DOC17/622723
DA 367-11-2002-i MOD 3

**Redox Chemical Warehouse, Minto (DA 367-11-2002-i MOD 3)
Environmental Assessment Requirements (EARs)**

ATTACHMENT A
DPE comments dated 26 July 2017

ATTACHMENT B
DPE comments dated 20 October 2016

Figure 4-1: Site Plan

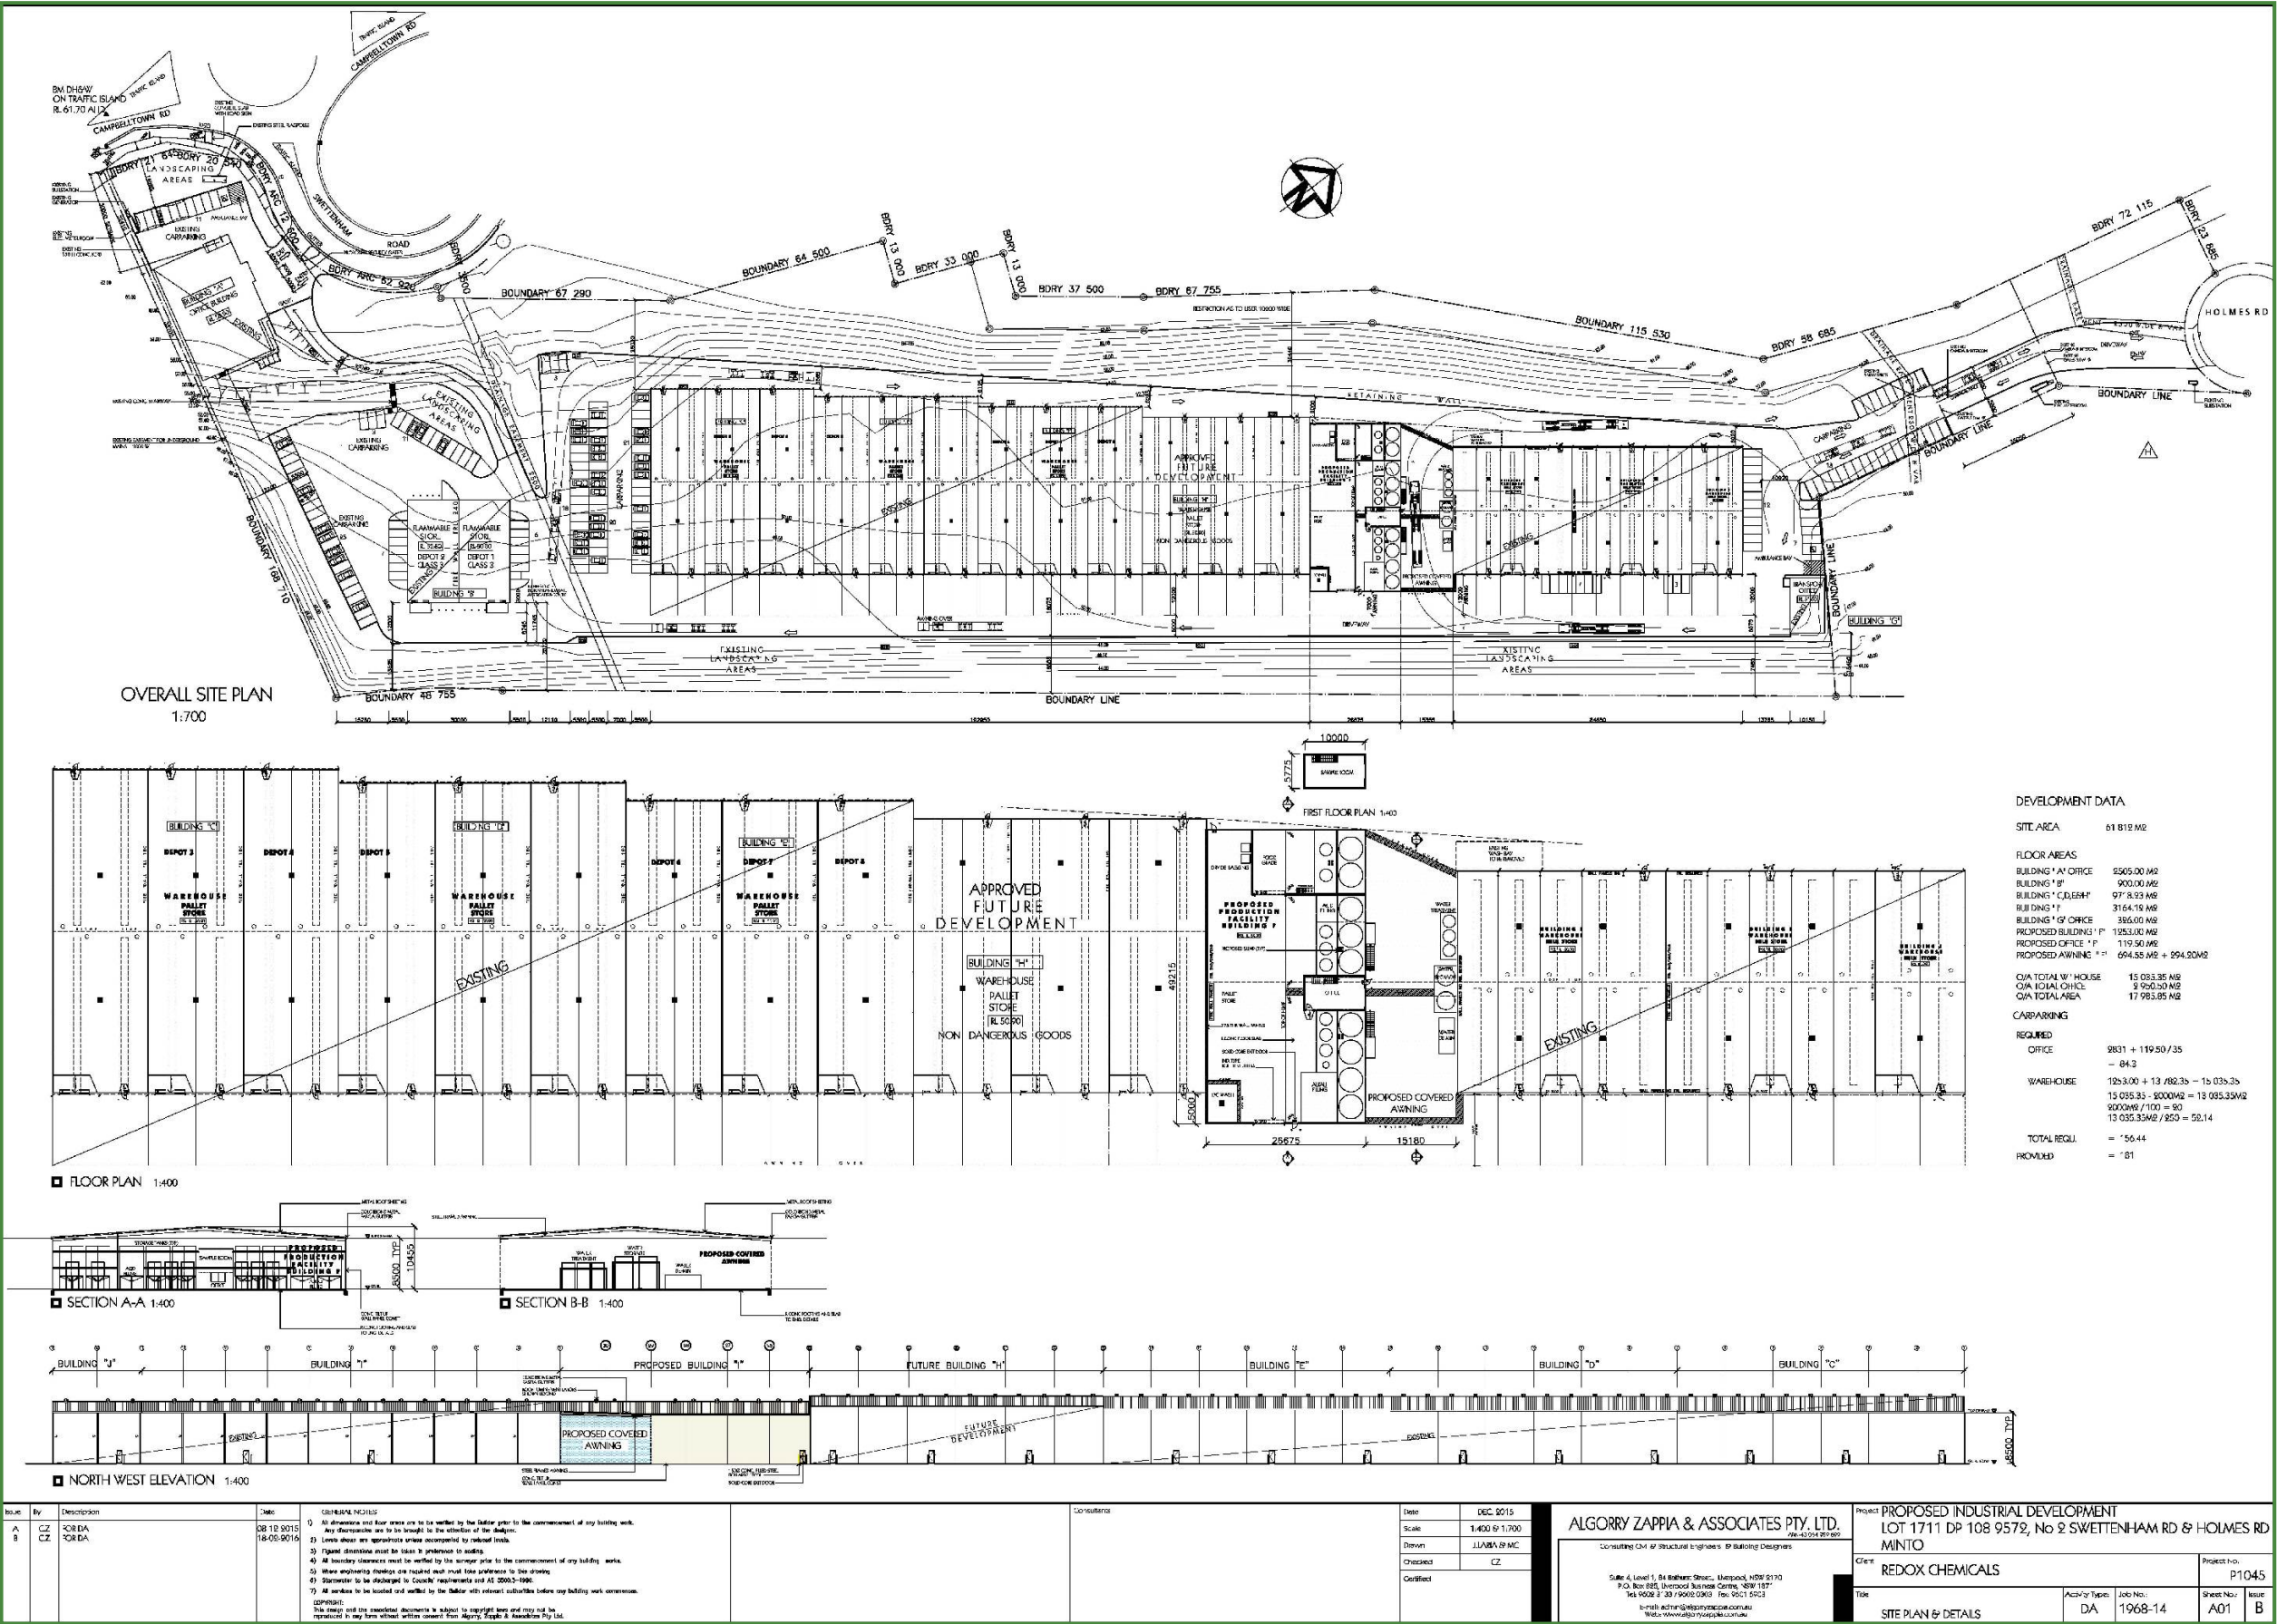
- Figure 2-1 should be updated to include labels which identify surrounding developments (as described in Section 2.1.2.2).
- Figure 3-5 *Site Plan* should be updated to improve its legibility, and a site plan indicating the types of Dangerous Goods (DG) to be stored in each warehouse/area should also be provided.

Figure 4-2: Dangerous Goods Locations

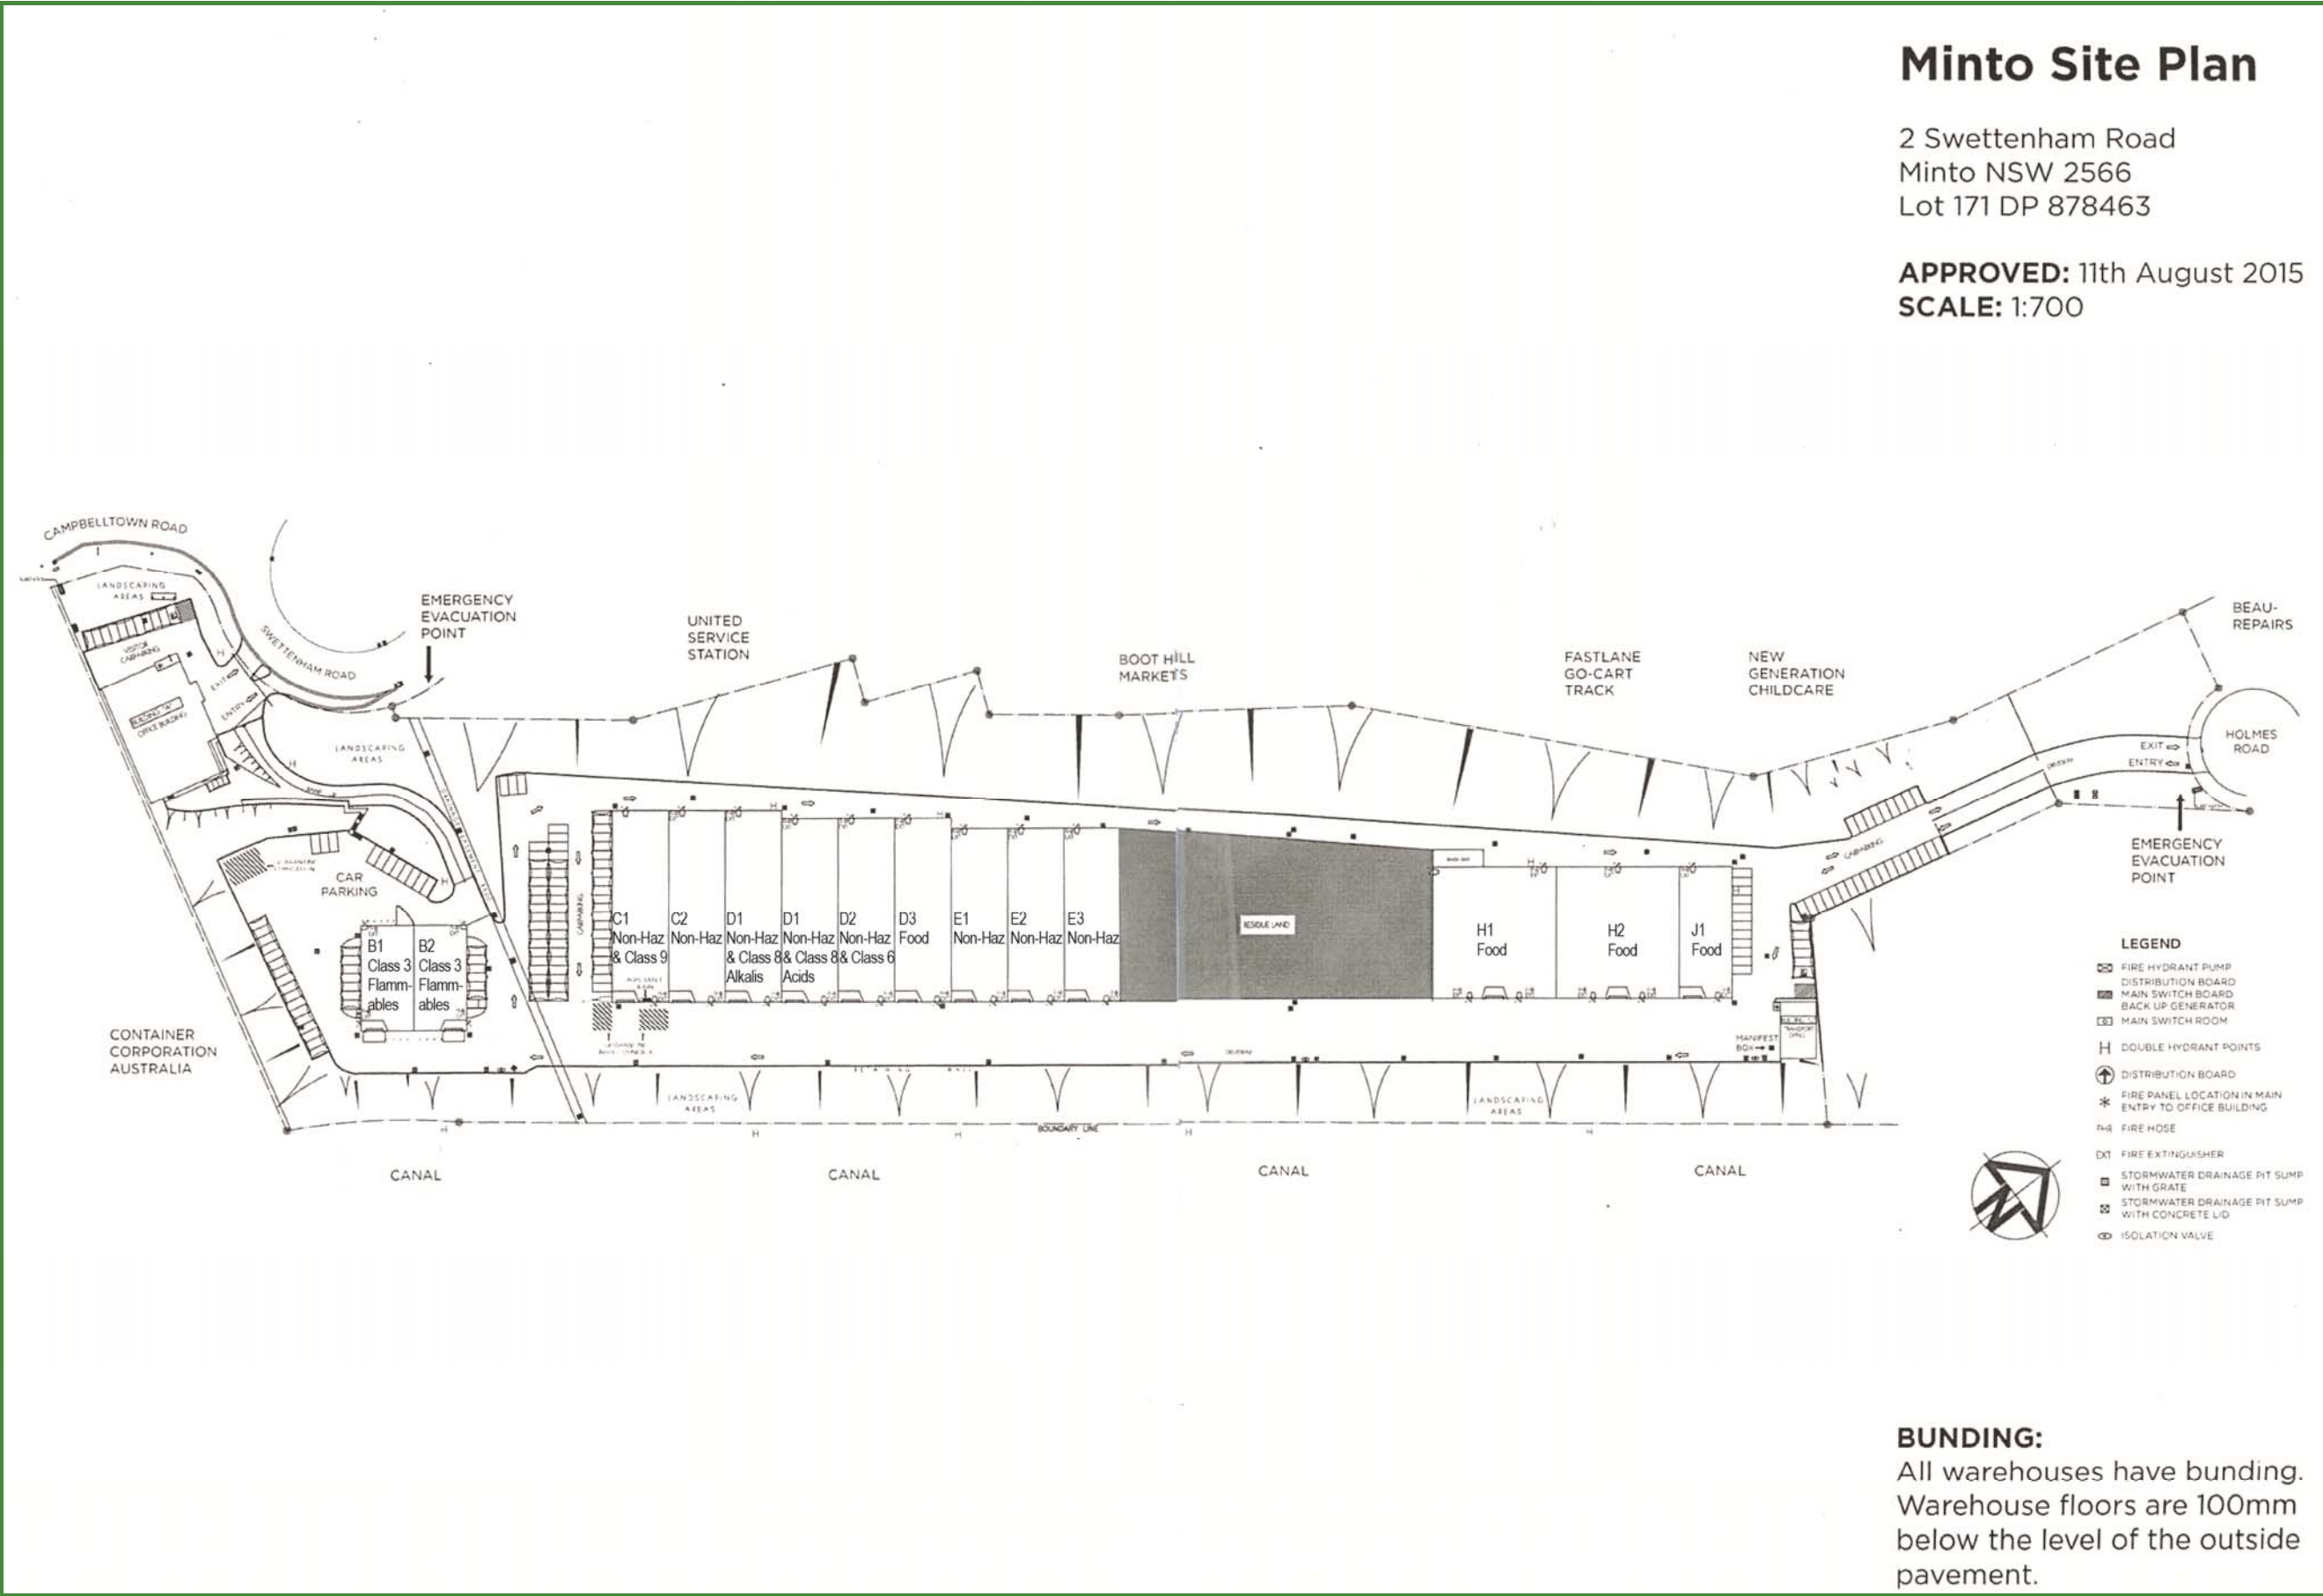
- Specific storage locations for the Dangerous Goods and other materials within each Warehouses on site is not provided. The EA should include a DG site plan for both the existing site and for the revised DG site plan which forms part of the modification request.

Figure 4-5: Existing Truck Route

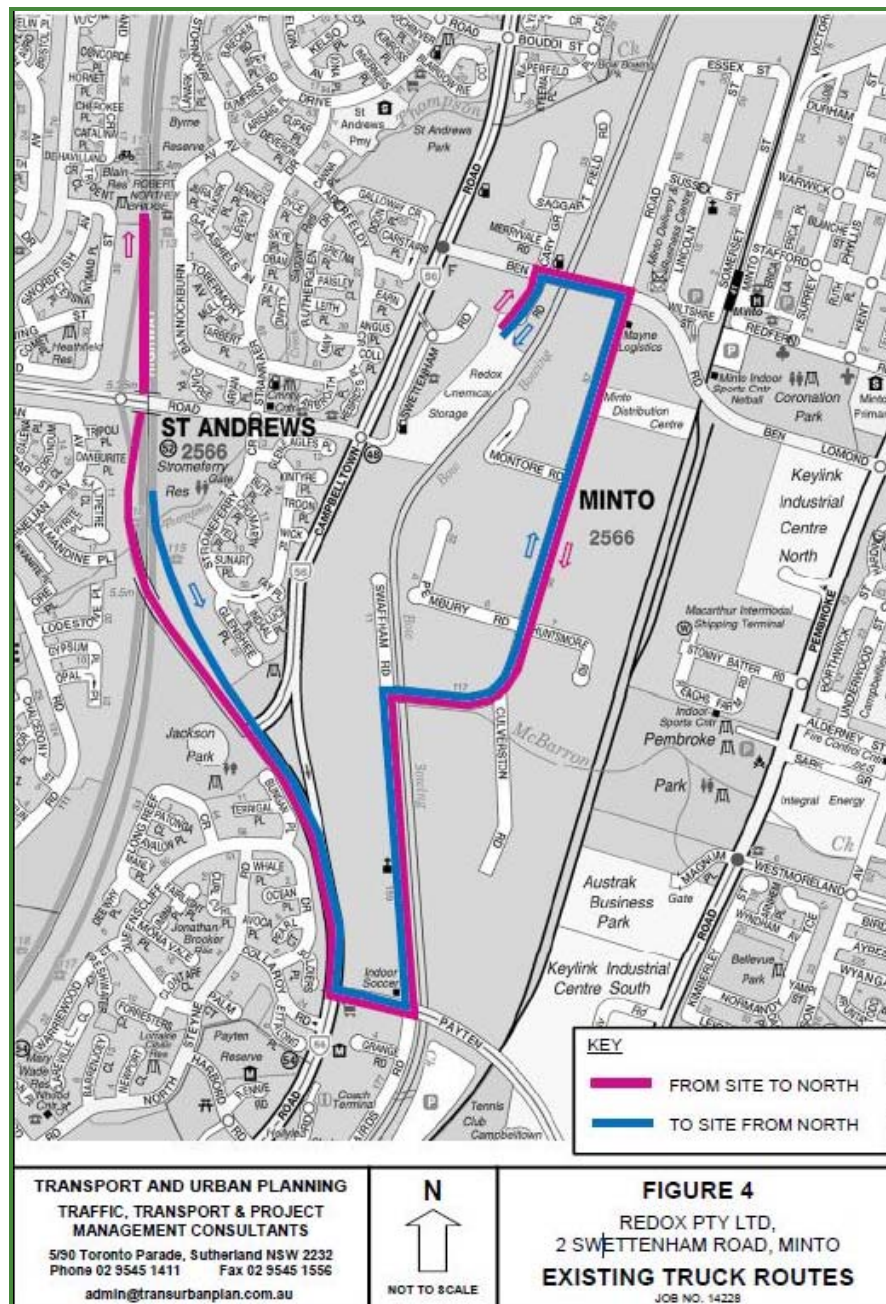
- The modification request should indicate whether it is proposing to change the approved number of vehicle trips as part of Stage 4. The EA should also indicate whether the additional traffic for Stage 4 has already been assessed and approved.
- The EA should clarify whether it seeks to modify the approved vehicle types (i.e. types and numbers of trucks/heavy vehicles).
- Section 3.3 of the EA should include maps of both the approved and proposed vehicle routes.
